Application number: 2025/91657	
What is the application for?:	Erection of first floor side extension (within a Conservation Area)
Address of the site or building:	Kelvin Villa, 1, Newsome Street, Dewsbury, WF13 4HE
Postcode:	WF13 4HE

PROPOSED FRONT ELEVATION
1:100 @ A1

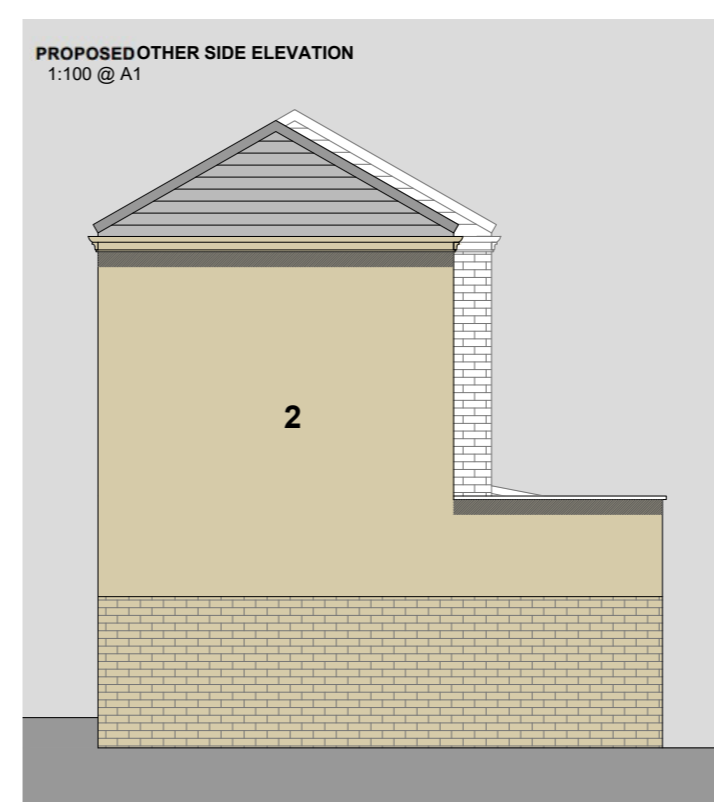
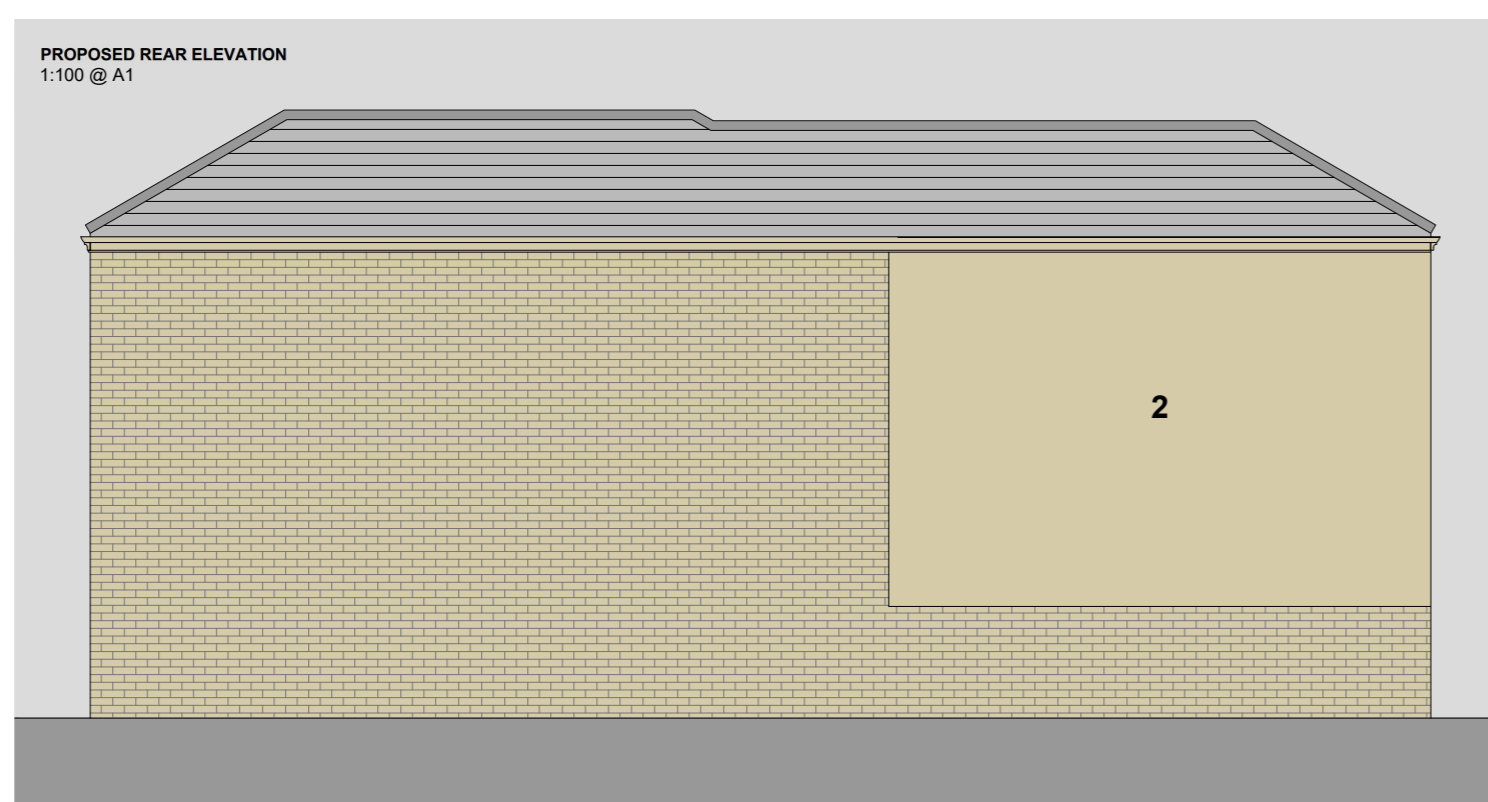
Type of comment: An objection	
Do you wish your comments to be published on the website anonymously?	<input checked="" type="checkbox"/> Yes
<p>Another disgusting proposal by 1 Newsome Street this must be rejected by the council During the previous extension which let me say was done illegally they blocked the alleyway</p> <p>This time I will not stand for this kind of behavior will call the police as they are trespassing on private land. I Have pictures of the blocking the alleyway, also have pictures of the tile looking bricks which they just threw on the alleyway/west park street</p> <p>Kirklees Council where is your duty of care to look after me?</p> <p>I strongly demand this proposal is rejected or this will be waste of tax payers money when I will keep on calling the police, I will also have to go to the national newspapers Proposed extension within a conservation area will make it look a right eyesore, rendering can't be used as this will not match the existing property</p>
